From: Simon Davis
Sent: 13 August 2020 13:19
To: 'Rob Riding' [REDACTED]
Subject: RE: Y/39/20/RES - Land at Street Buildings

Stratford
 Lifestyle

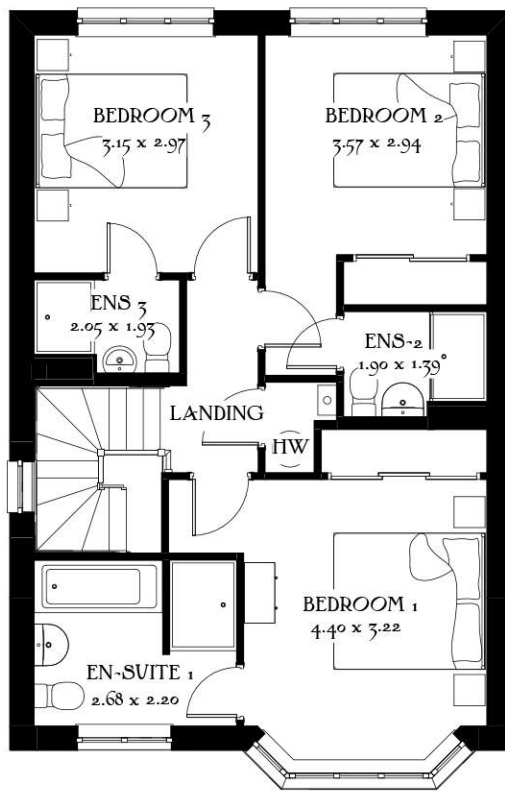
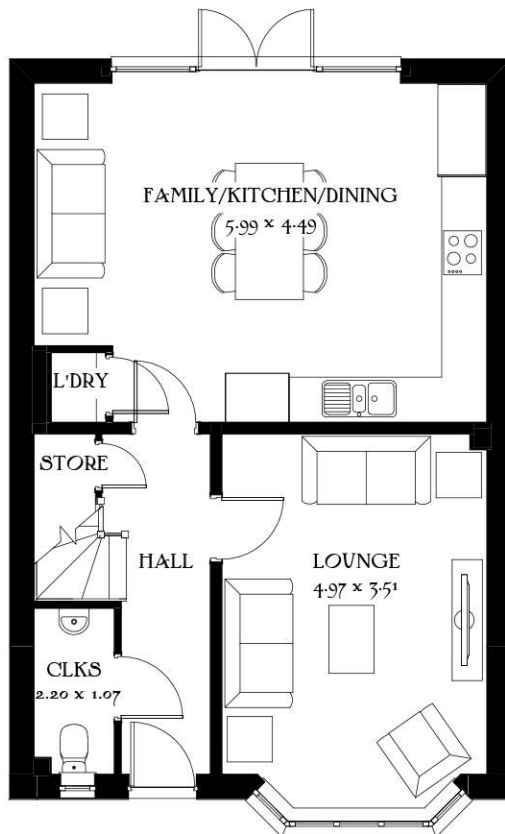
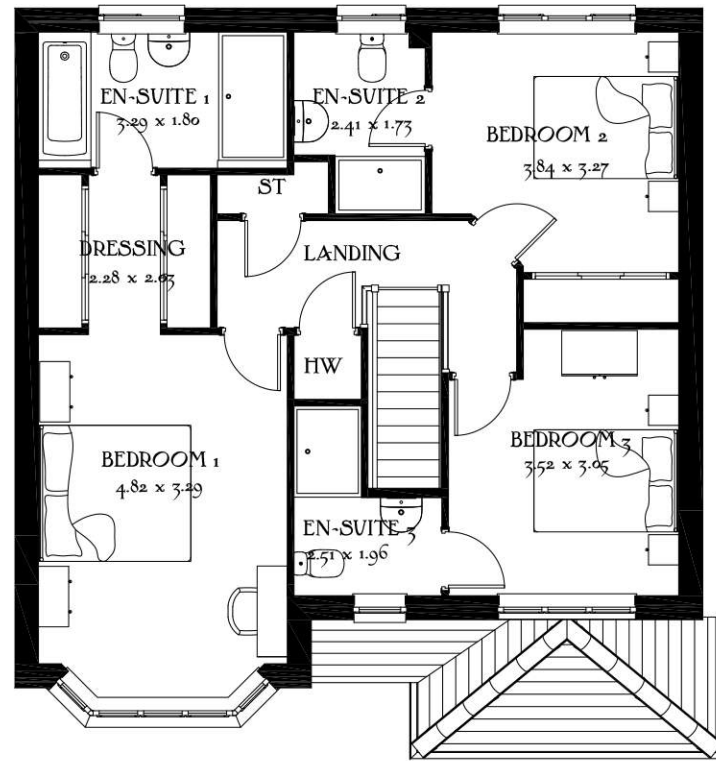
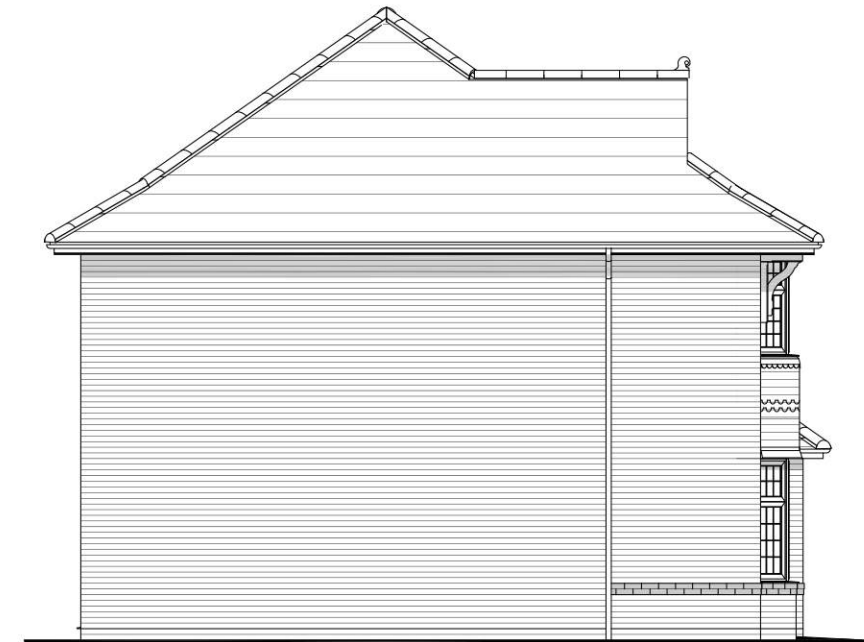
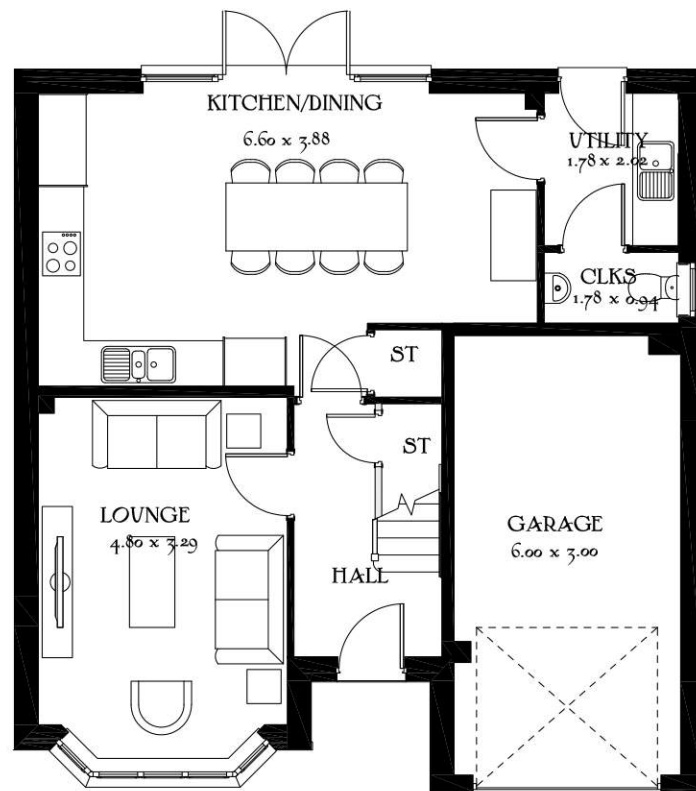
Stratford Lifestyle House Type – a window cannot sit within the en-suite as it would be next to the shower and again it would need to be obscurely glazed. Again there are structural requirements to be considered along this wall for Bedrooms 1 and 2 which limits the scope.

I spoke to my manager and he agrees with me that we cannot impose such a condition. It is different to an obscure glazing condition as that refers to windows already proposed in the scheme. However, whilst he agrees that the additional windows would be beneficial, he considers that it is not absolutely necessary to have these additional windows therefore he is happy to sign off my report without these included.

Title:
TAVY - A1/A2
ELEVATIONS

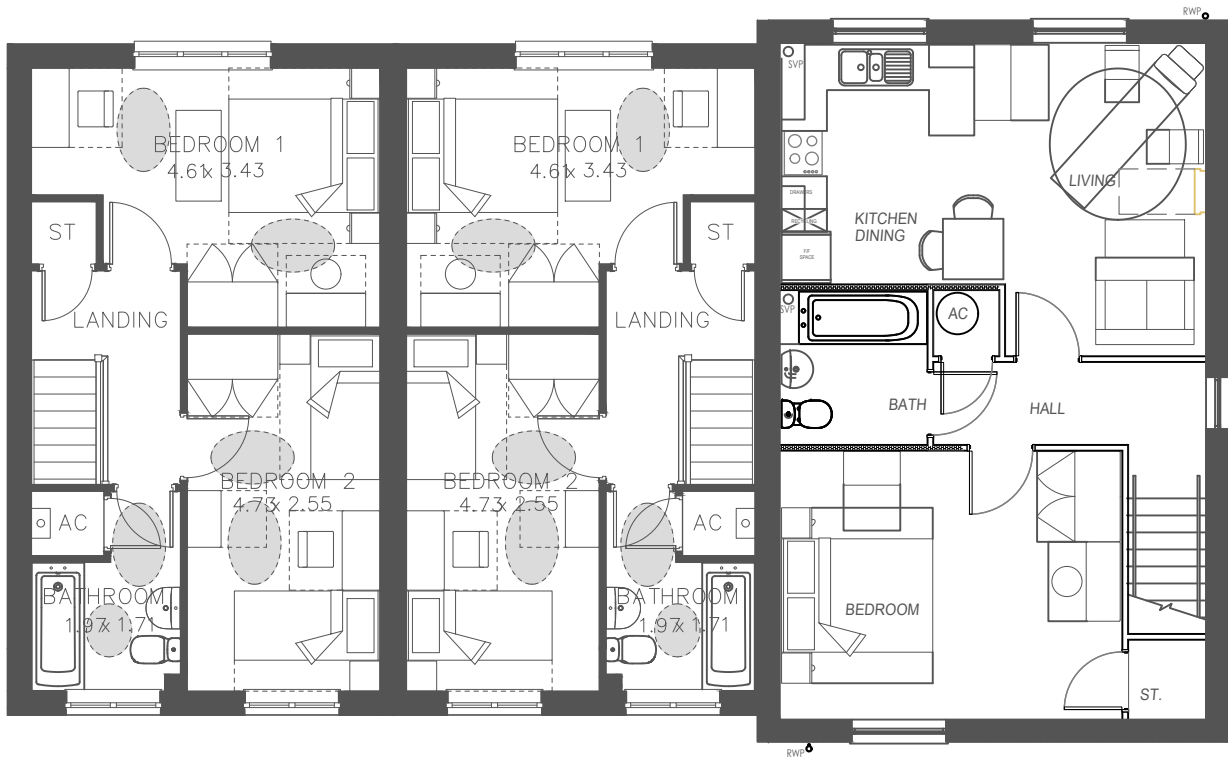
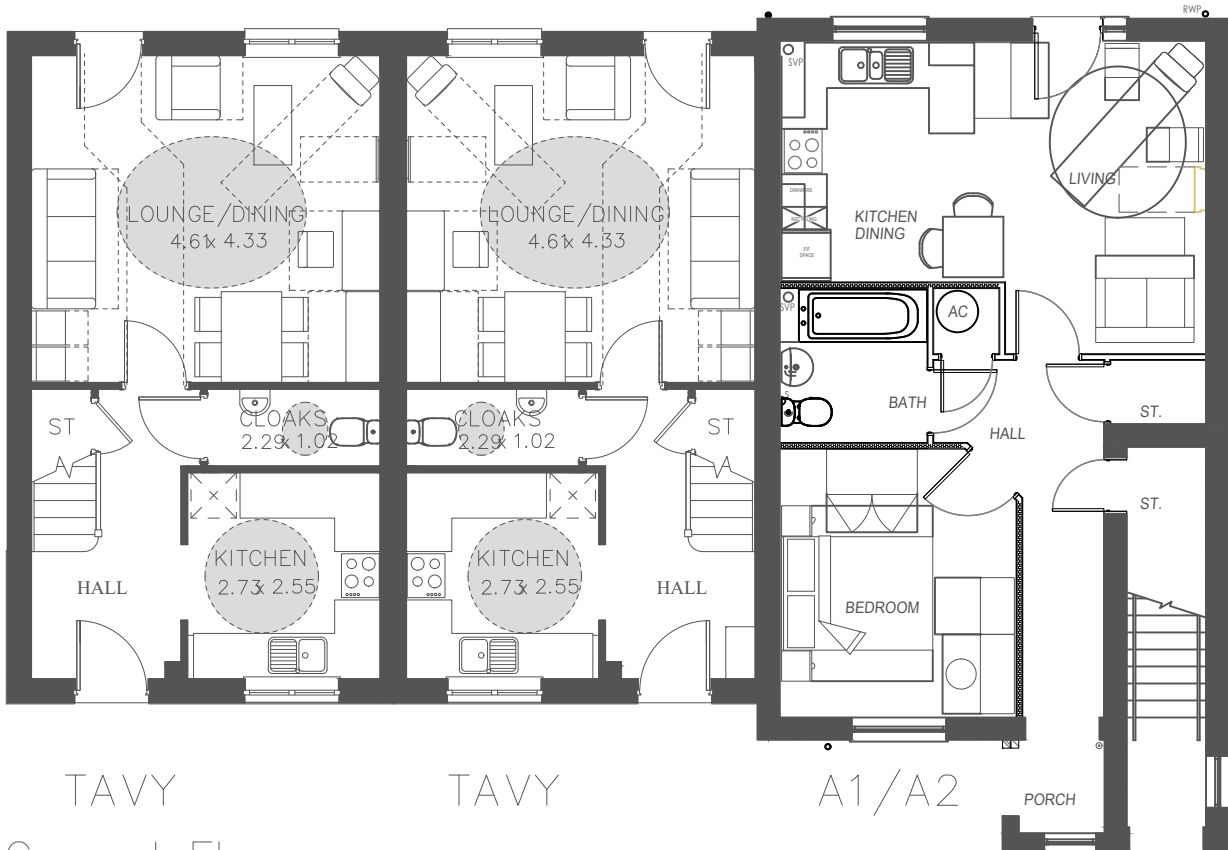
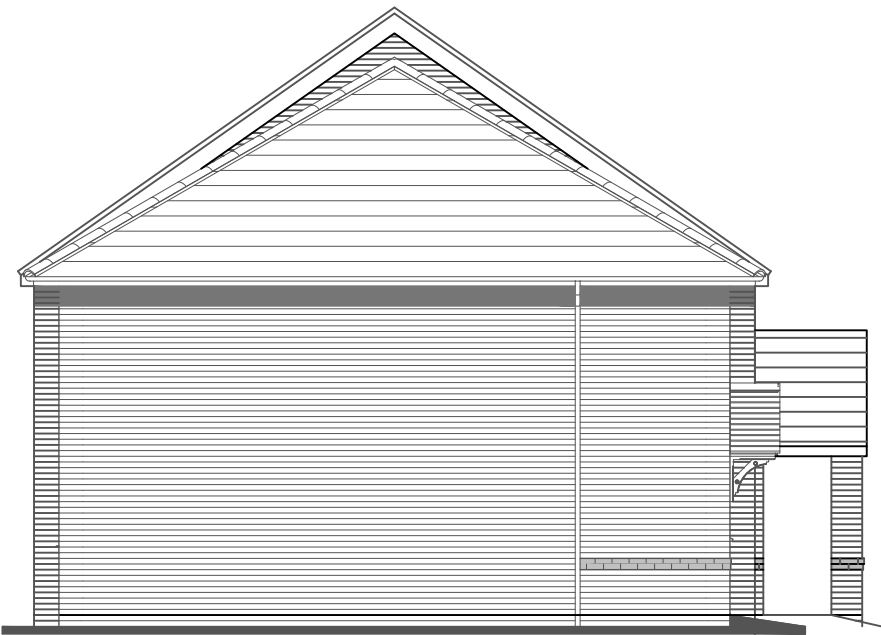
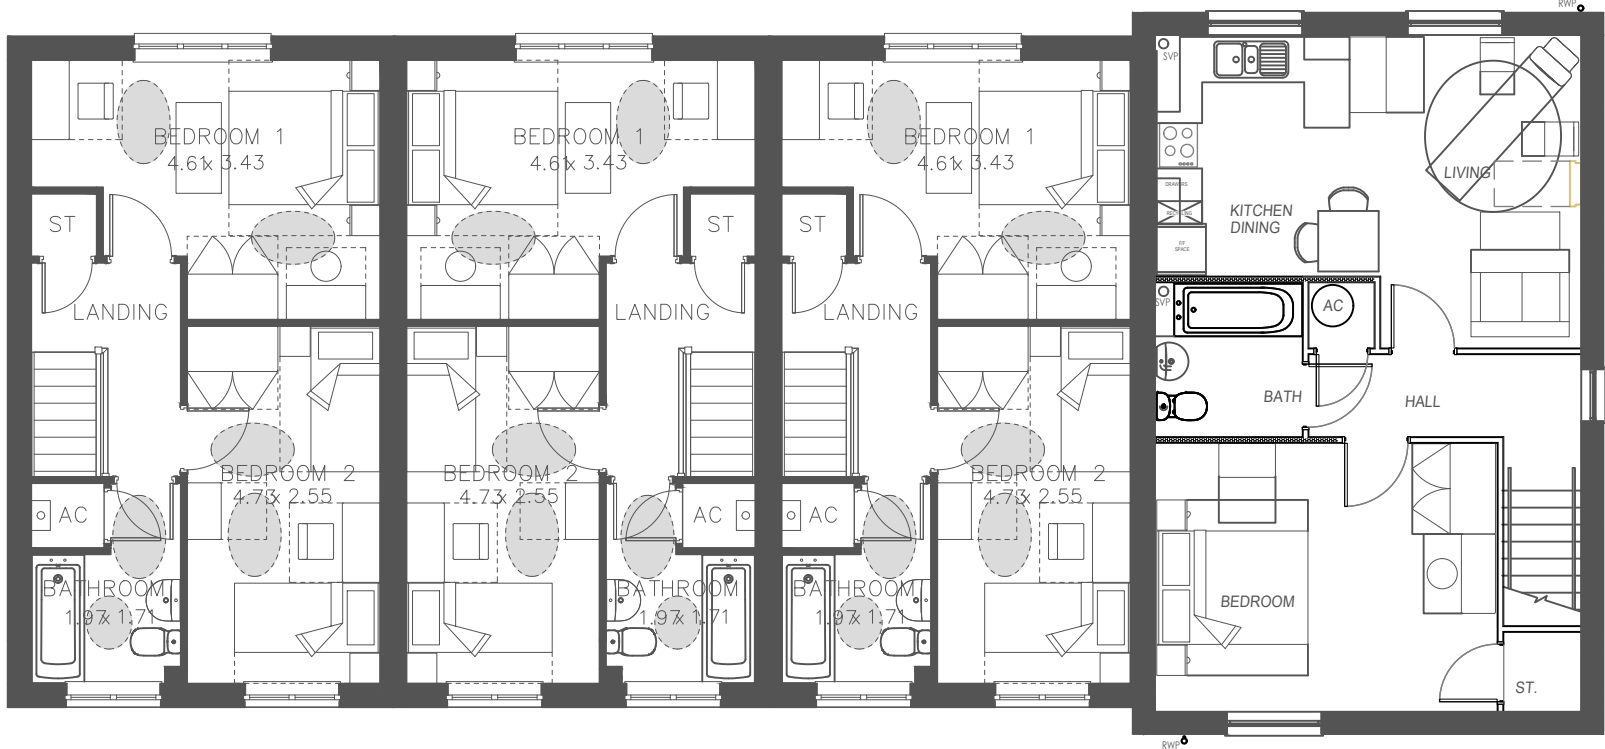
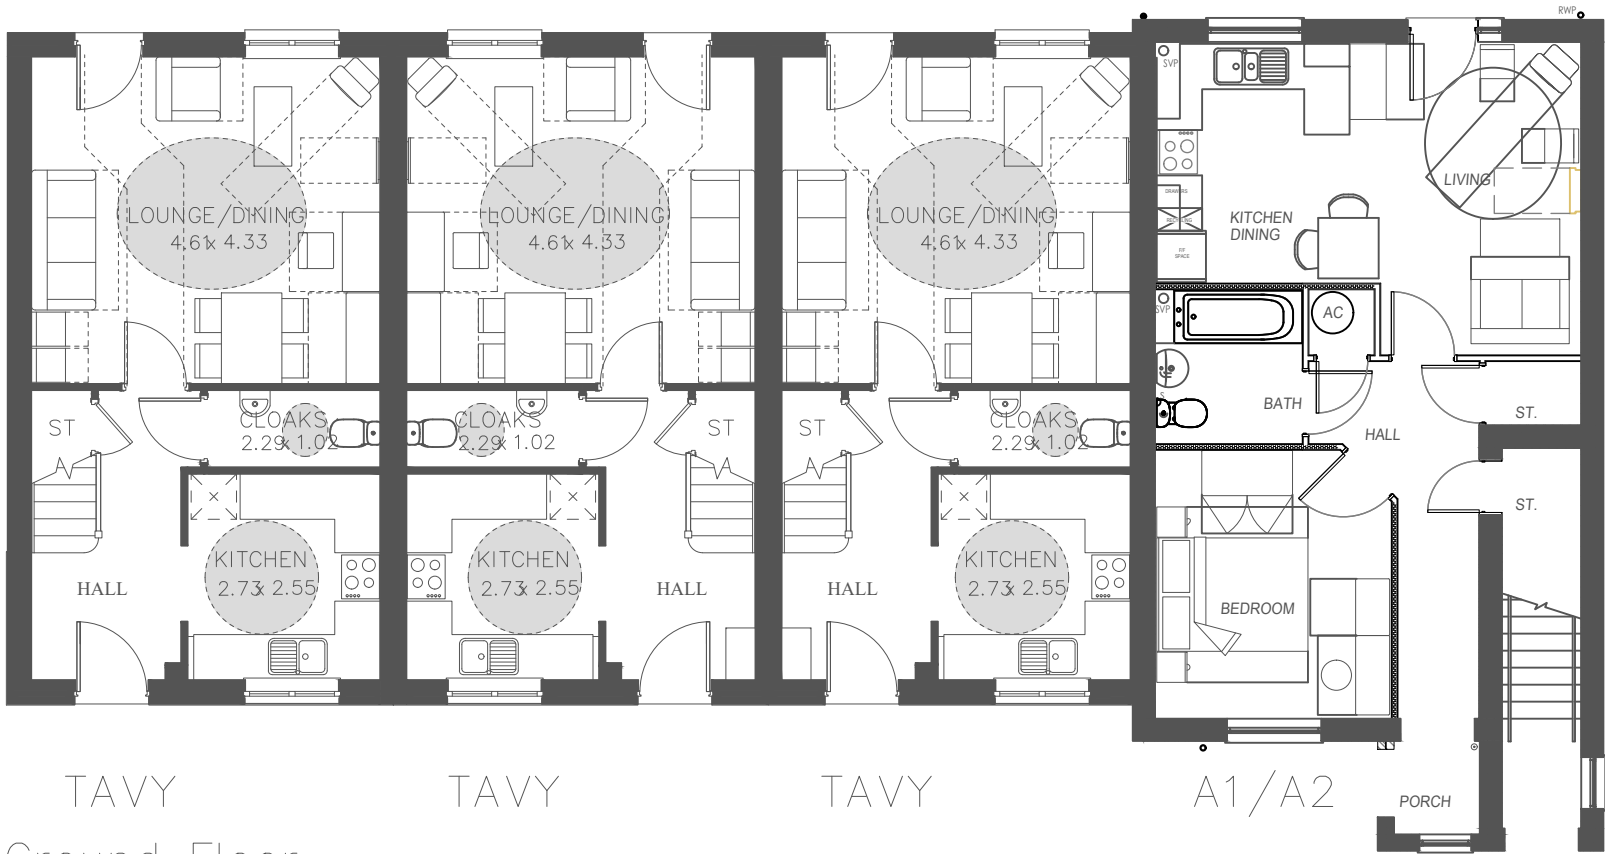
Also, I don't appear have any plans for the new maisonette house type called "A1/A2" on the layout plan.

Also, the floorplans and elevations for the Tavy A1/A2 properties are included in the House Type Brochure – see drawings 063, 064, 065, 066, 067, 068, 069, 070.
